Stage 1 Road Safety Audit

BusConnects Core Bus Corridors
- Blanchardstown to City Quays

Document Ref: P20-138-PSW1-RP-001

Drawing File Name: BCIDC-ARP-GEO\_GA-0005\_XX\_00-DR-CR-0028

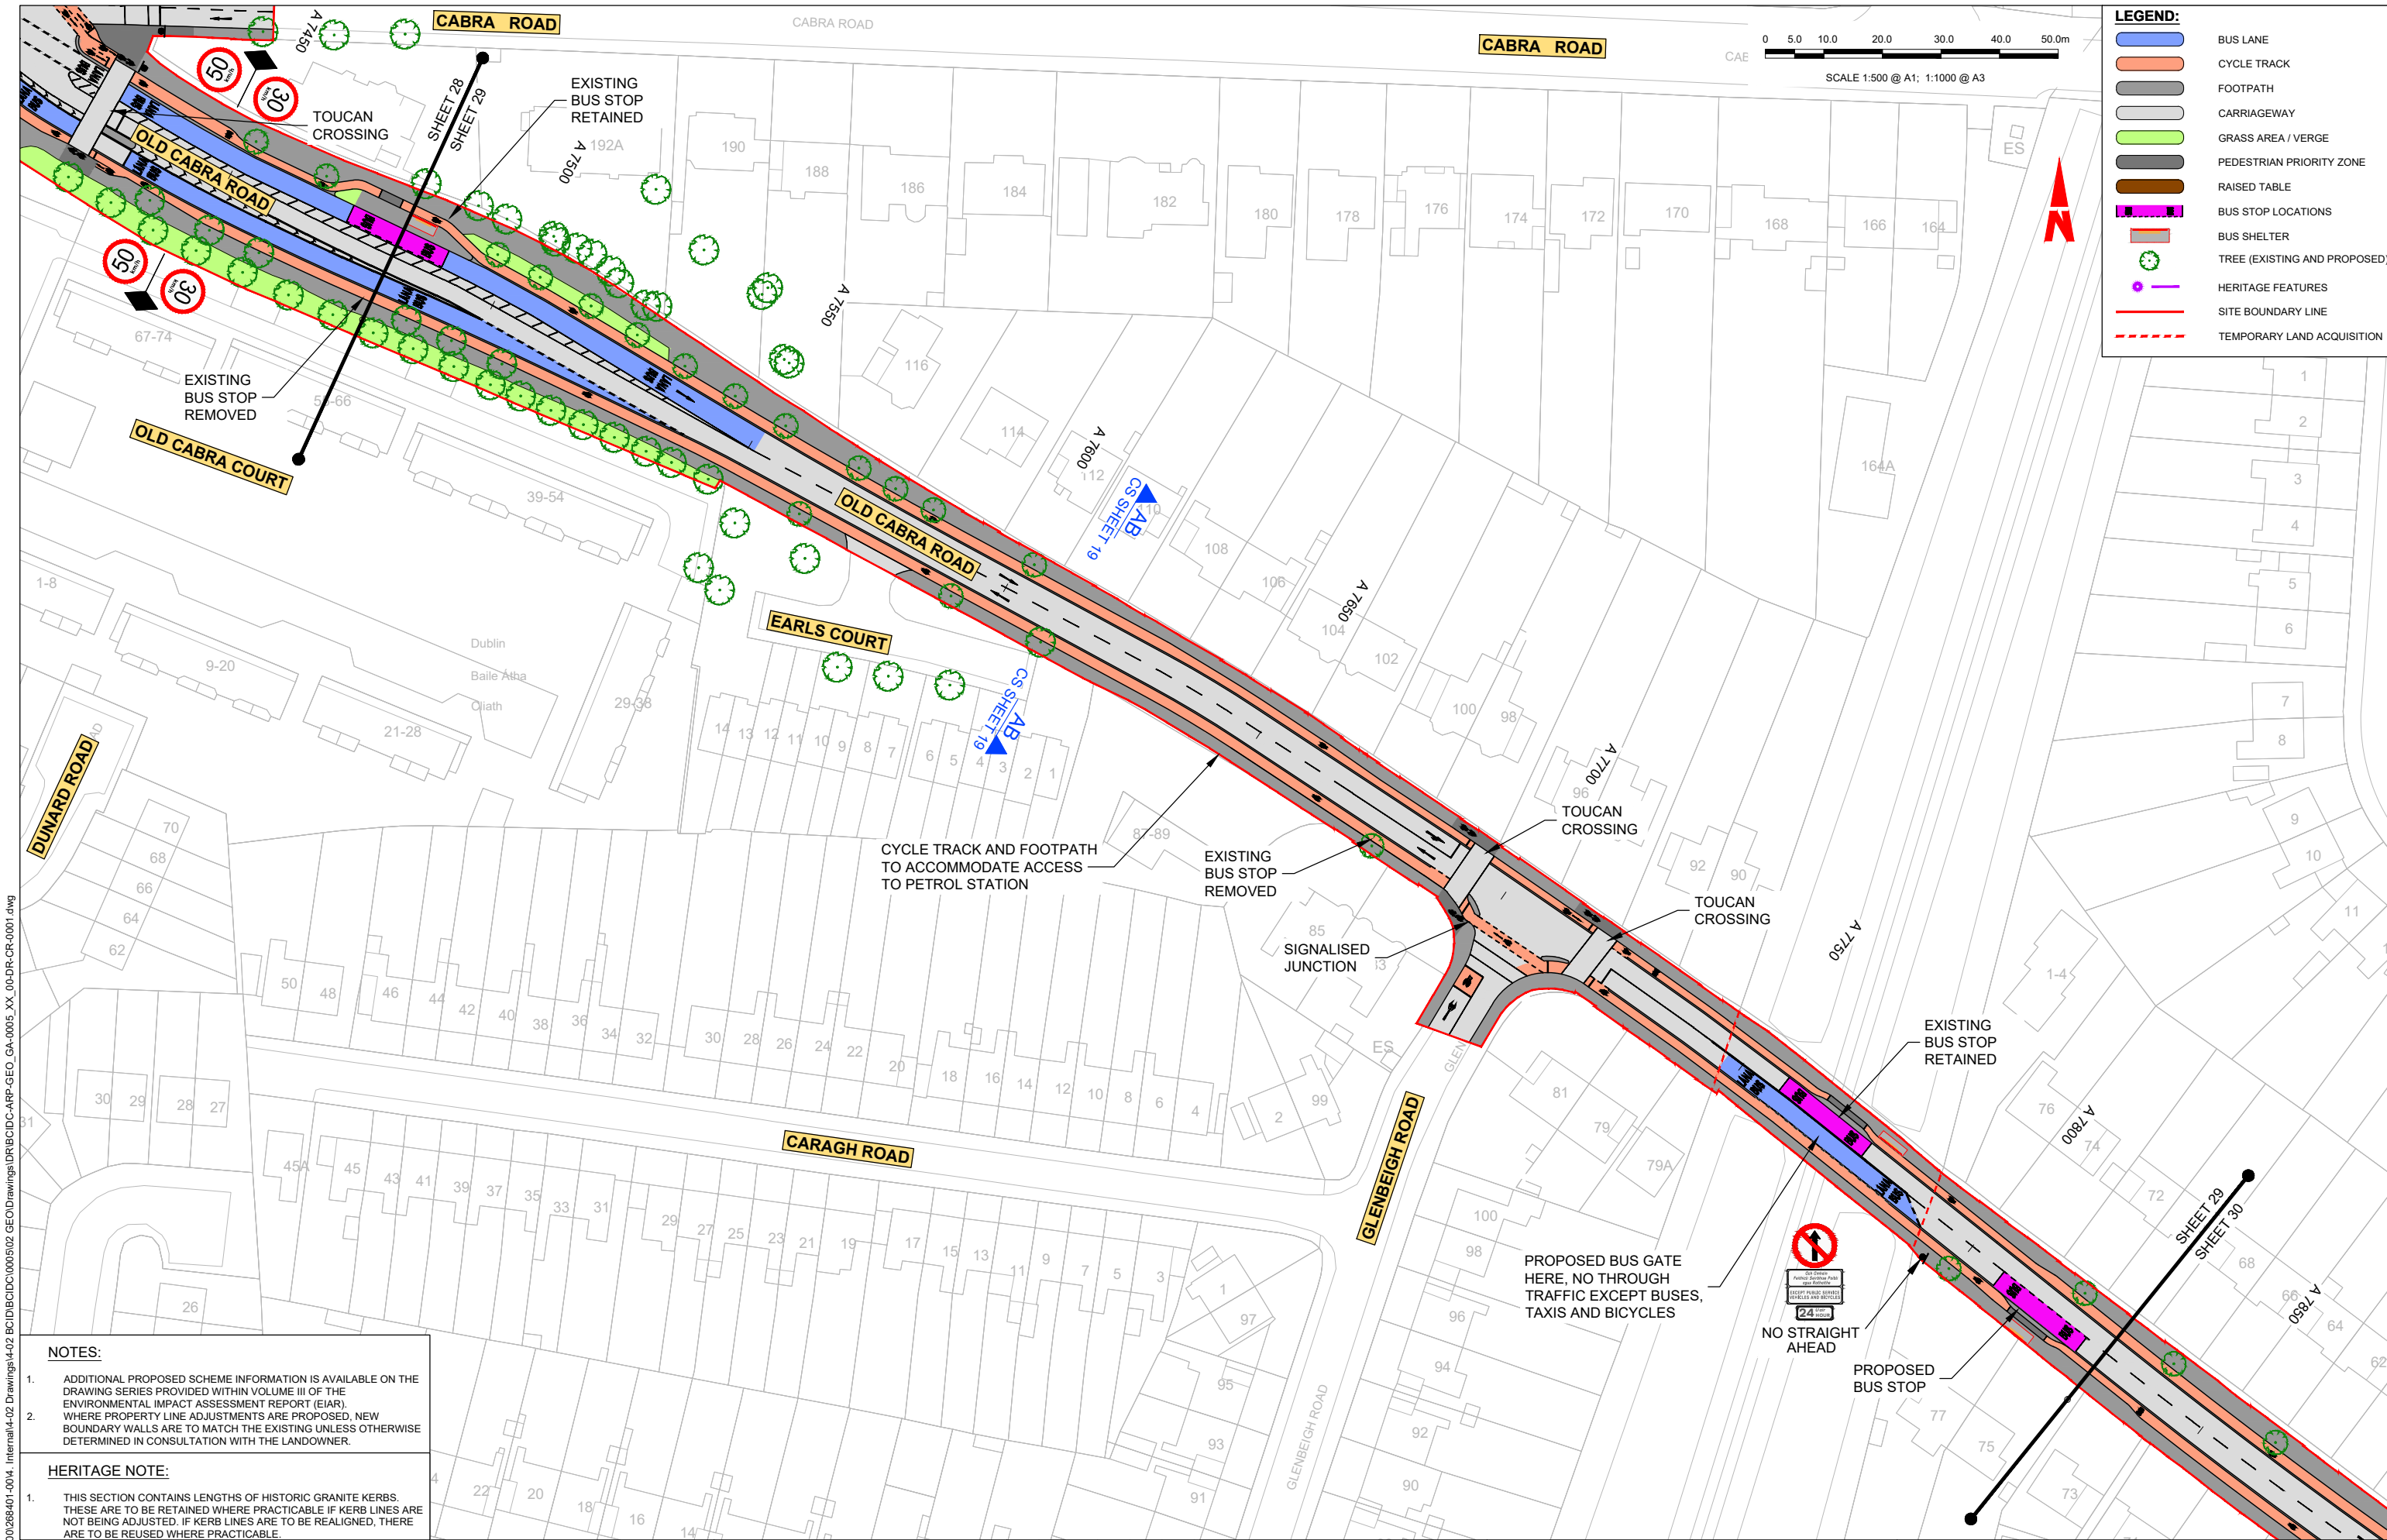
Summary: Unclear how cyclists are intended to turn right at some protected intersections.

Protected intersections have been indicated at a number of junctions within the Scheme including the Old Cabra Road/North Circular Road junction and on the Navan Road at its junctions with Kinvara Avenue, Nephin Road and Skreen Road. It is unclear how it is intended that cyclists should turn right at these junctions as no measures appear to be provided to facilitate this manoeuvre.

This could lead to cyclists entering/crossing traffic lanes where there is an increased risk of being struck by a vehicle. Alternatively, cyclists may attempt to use the pedestrian crossings which, if these are not toucan crossings, may not safely accommodate both cyclists and pedestrians.

Cyclist 'box turns' should be provided ahead of the stop line, but outside the through cycle lane at these junctions. This will allow right turning cyclists to exit the through cycle lane and wait in this right turn box for a green phase on the side road where they can then proceed straight ahead with through traffic. These may require the position of the pedestrian crossings and stop lines on the side roads to be amended.

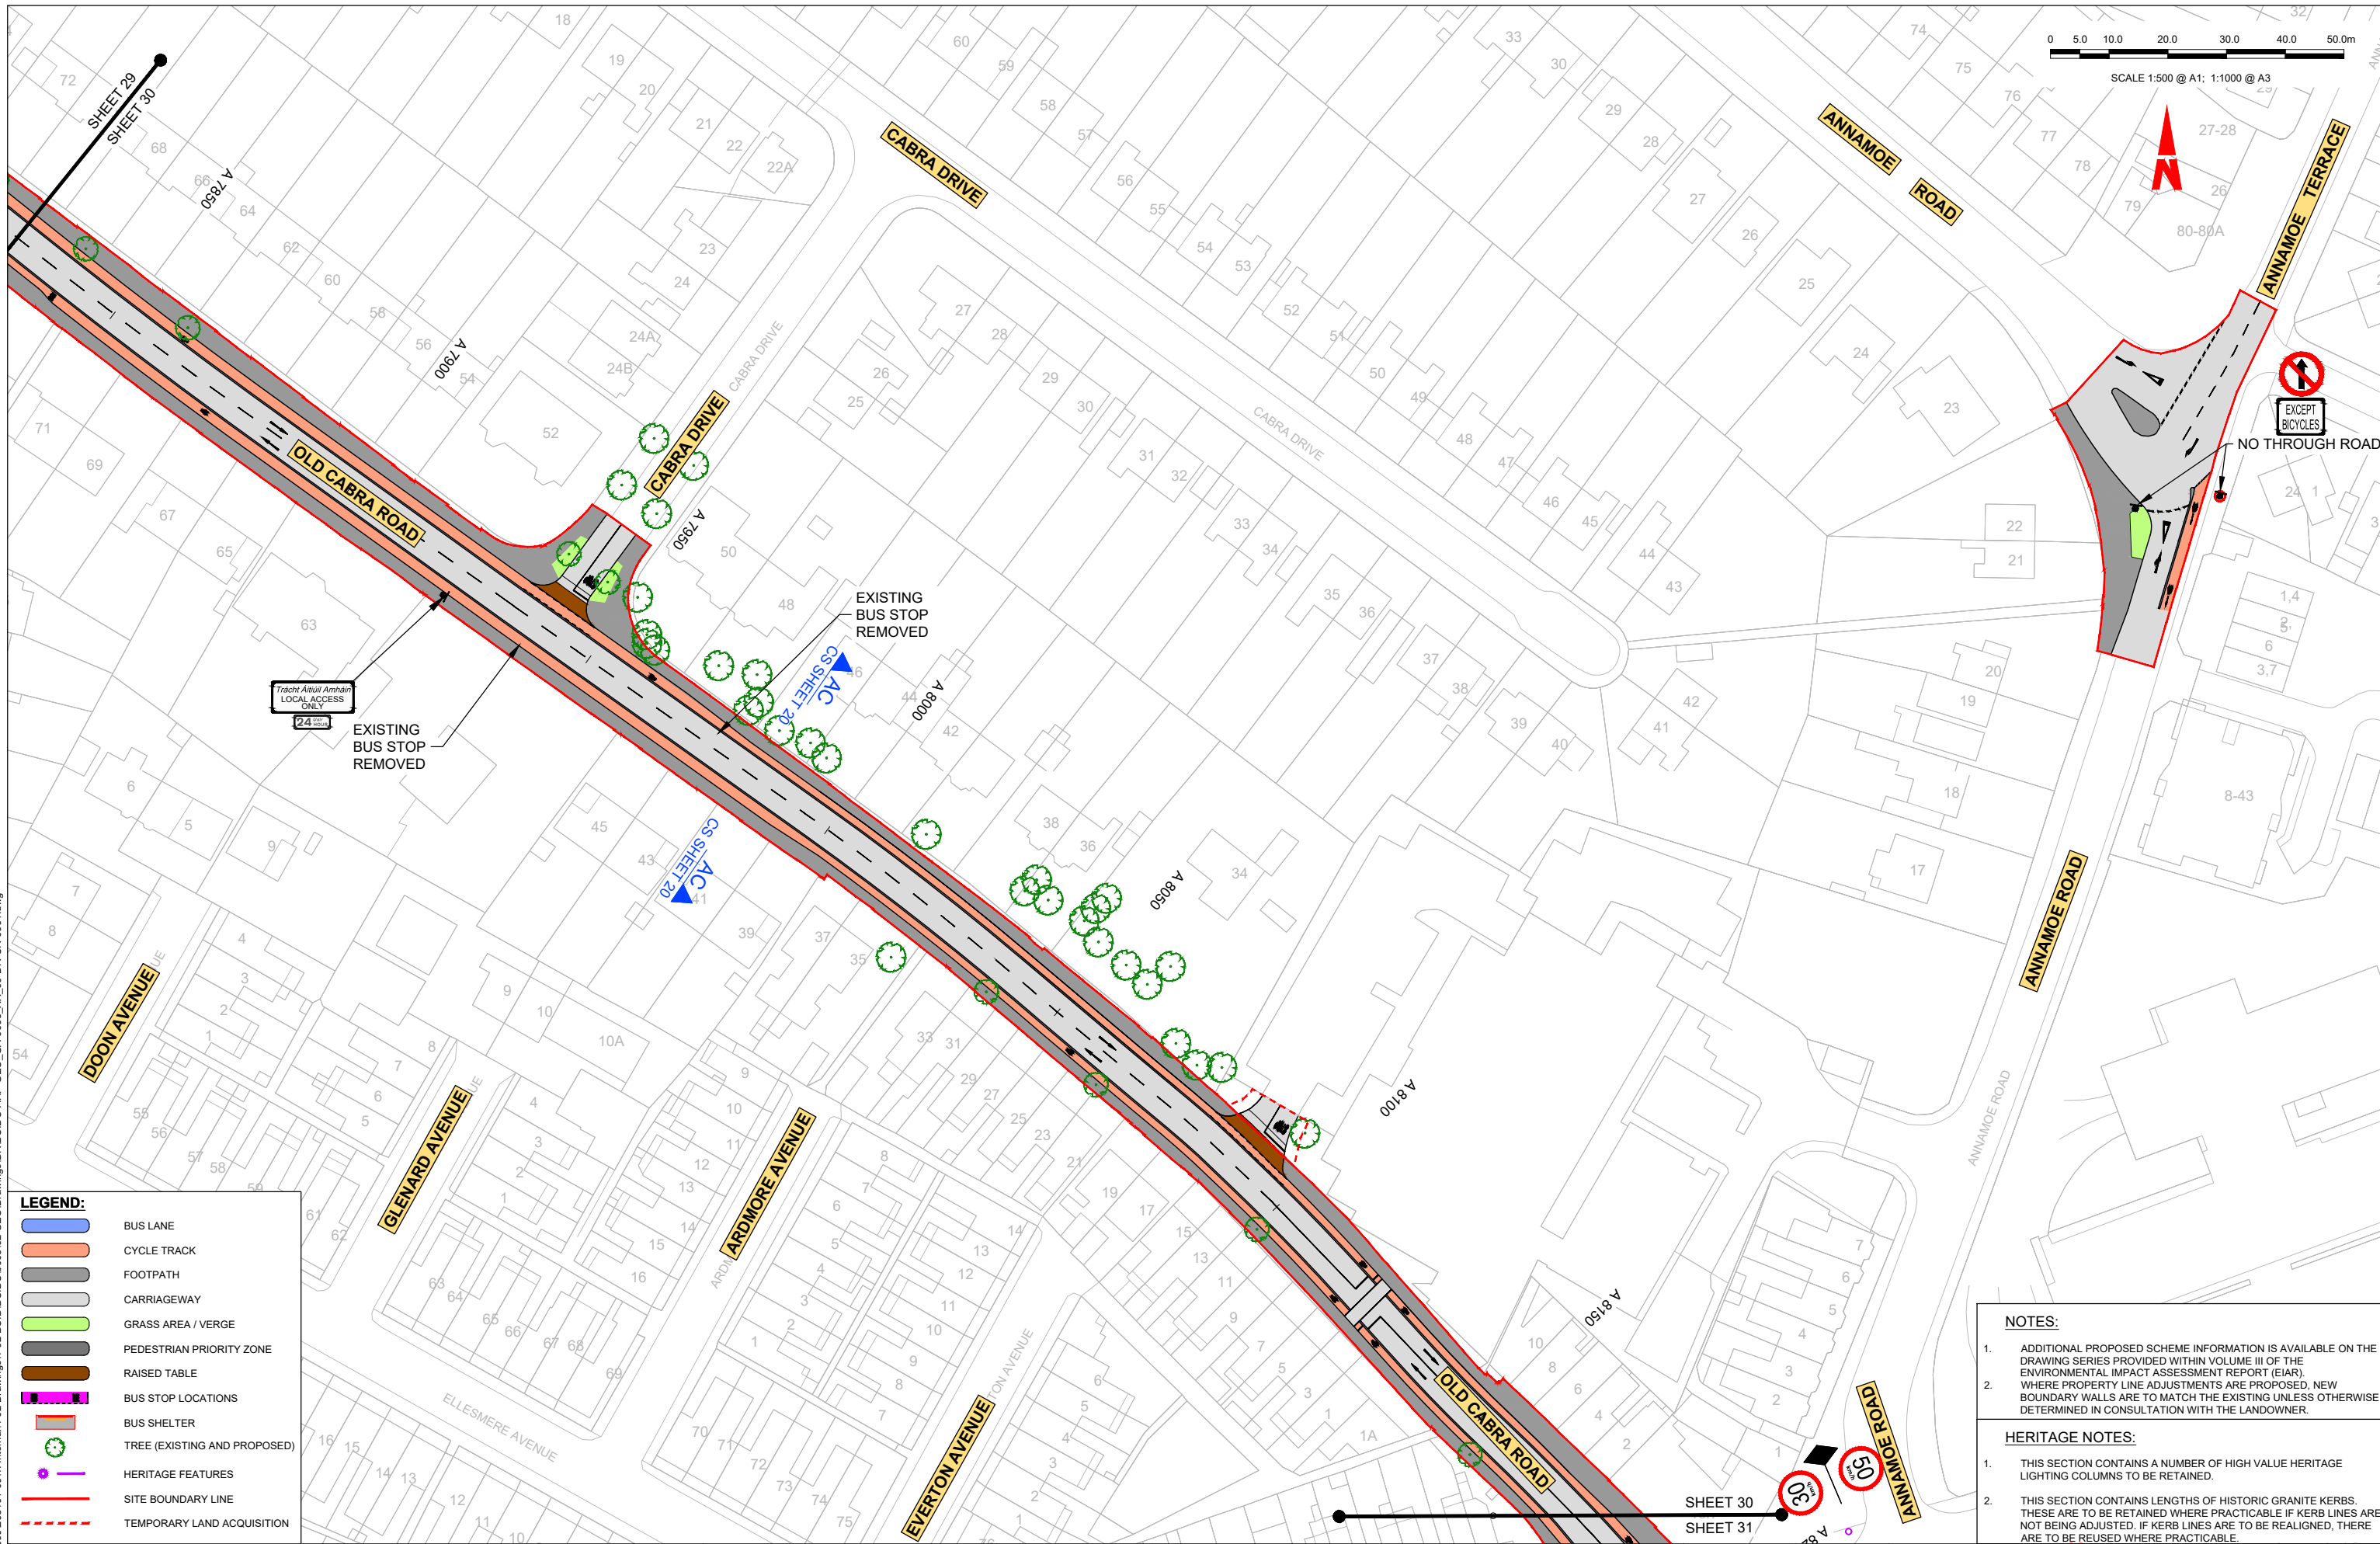
Summary: Heritage features indicated within the footpath and cycle track may present obstacles to pedestrians and cyclists.
